**FASS BUILDING
UNIVERSITY OF SYDNEY**

ACCESS REVIEW

Morris-Goding Accessibility Consulting

19 May 2016

project F.A.S.S. Faculty of Arts & Social Sciences
 drawing LEVEL 2 PLAN
 drawing no. DA1020 issue G

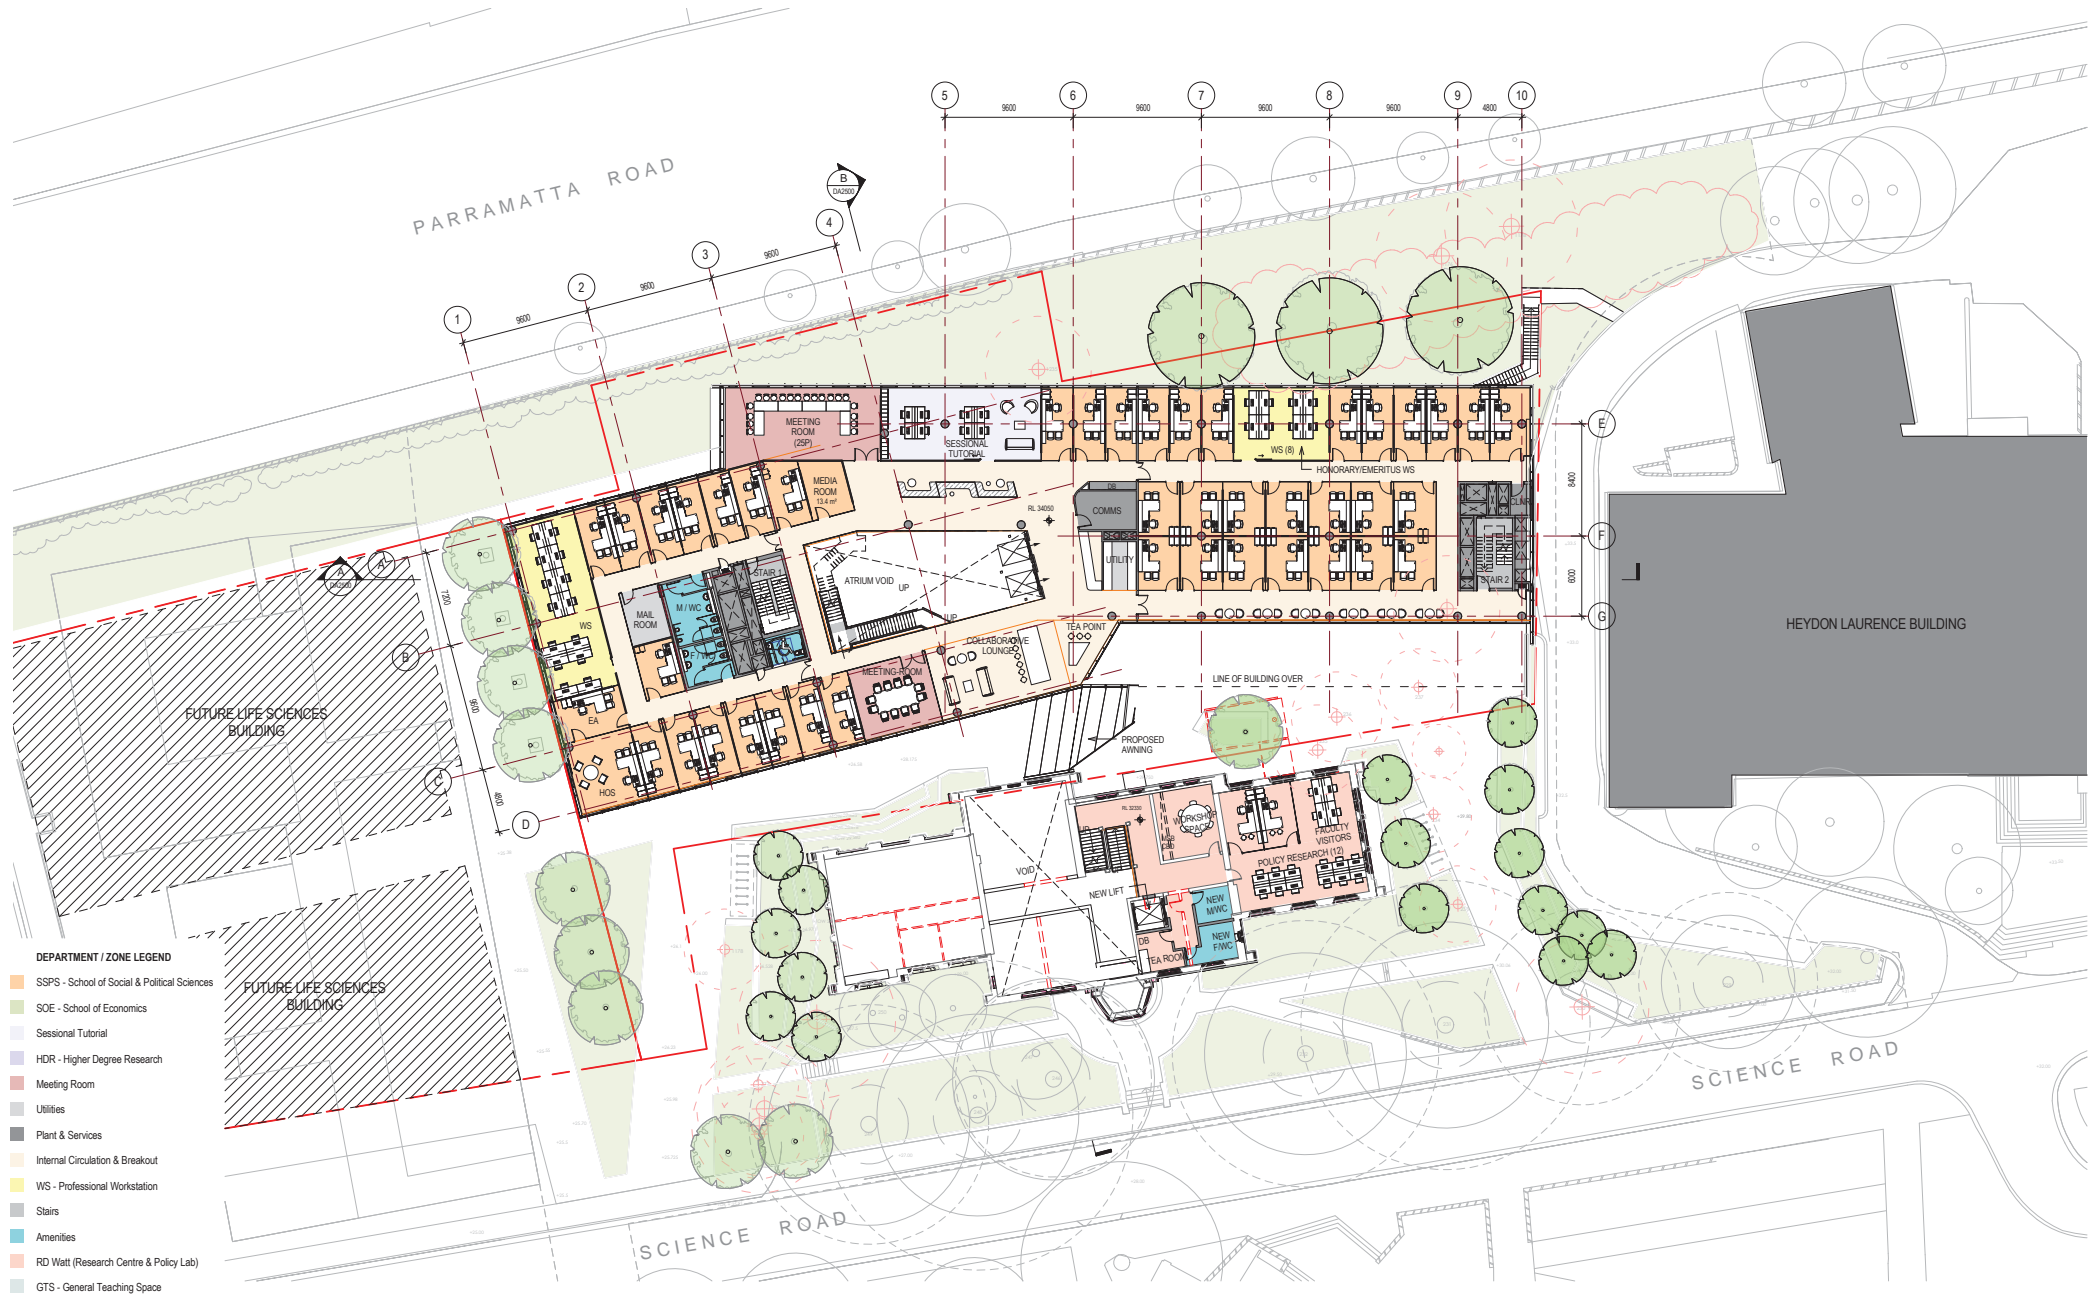
Recommendation:

- (i) Ensure there is an unobstructed accessible path of travel from pedestrian footpath to the main entry doors.

- (i) The level 2 entry vestibule requires 1450mm clearance between door swings in accordance with AS142.1.

- (i) The accessible toilets will require a balance of left and right handed pans throughout the floors in accordance with DDA Premises Standards.
- (ii) The level 2 accessible toilet should have an automatic door to be in line with the University of Sydney Access Guidelines
- (iii) Accessible toilets to have fixtures and fitting that comply with AS1428.1.
